# DRAINAGE LETTER

## LOT 11, ROLLING THUNDER BUSINESS PARK

County File No.: PPR-21-24

SUBJECT: Drainage Letter  
Lot 11 Rolling Thunder Business Park

# MALTESE - ROLLING THUNDER LOT 11 PPR

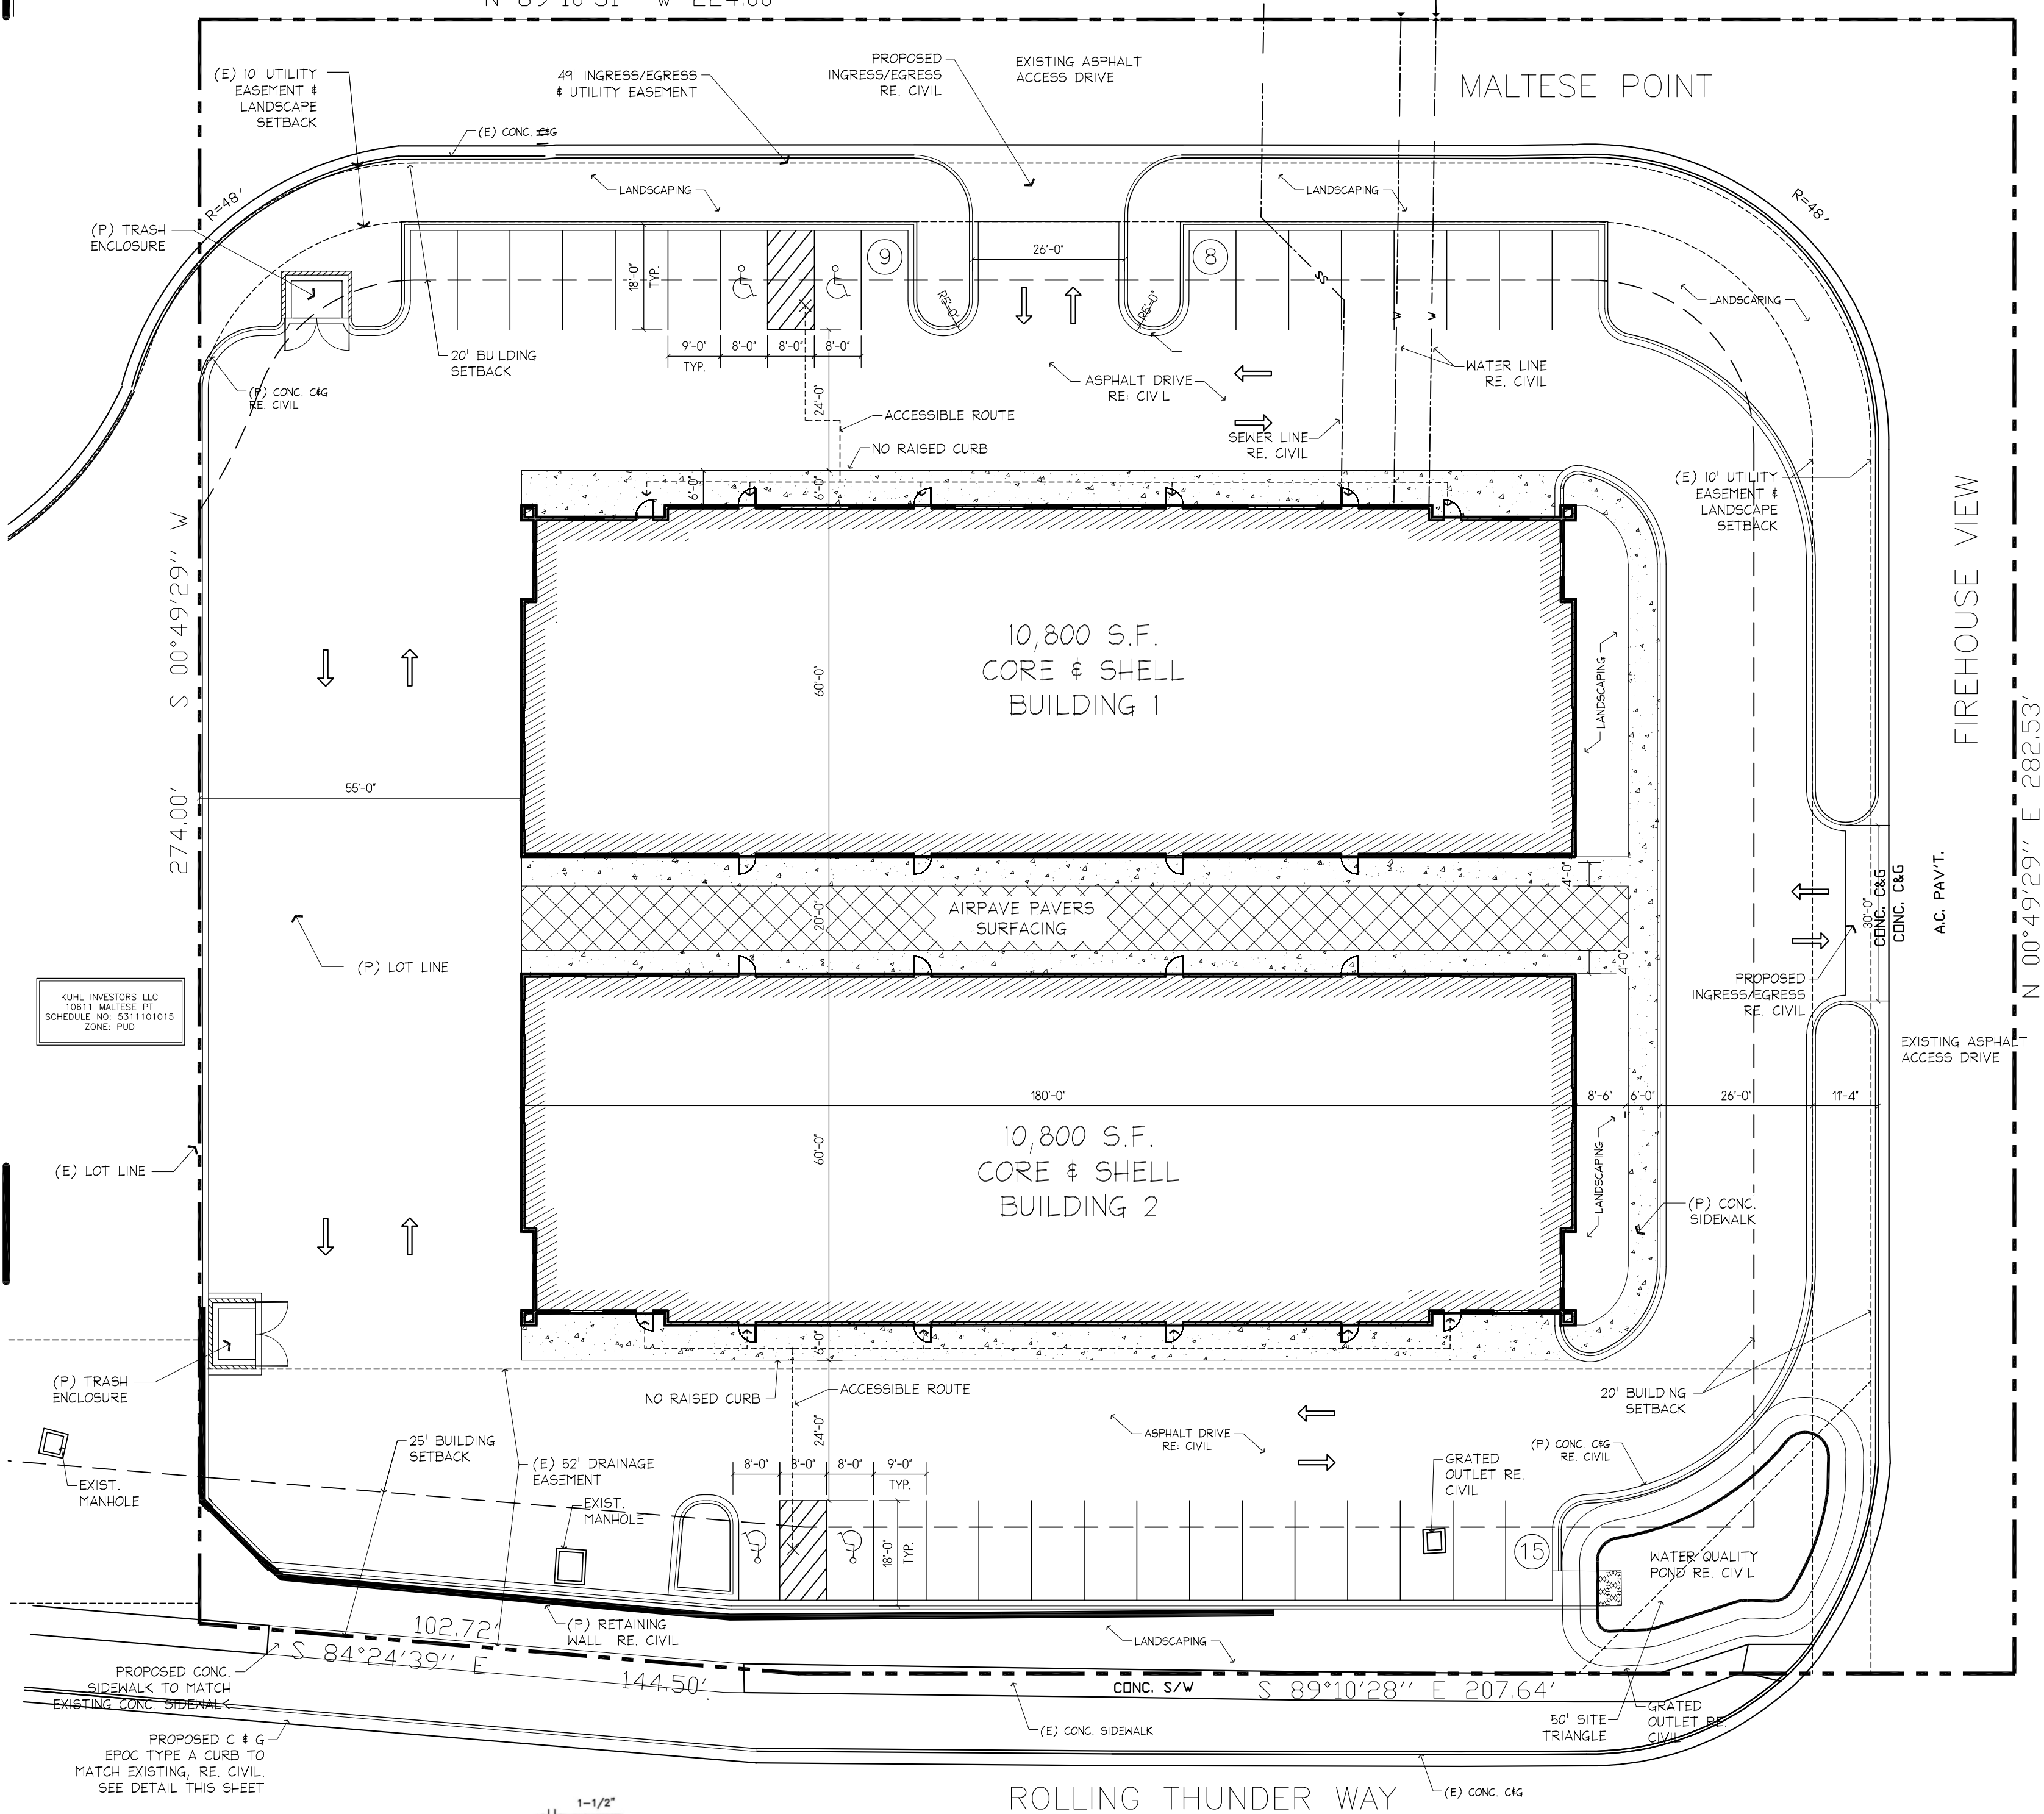
Need table/site plan breakout to show landscaped areas. Site Plan reflects lower value of only ~16% for landscaped areas and 84% for Imper. area See notes below. This causes pond undersizing and needs correction.

Value not in agreement with landscaped to impervious area as reflected on site plan Calculation put this value at 84% Pond undersized by ~783sqft versus 699sqft

This area is larger than the basin area "A" on the site plan or your developed area on page 5 above
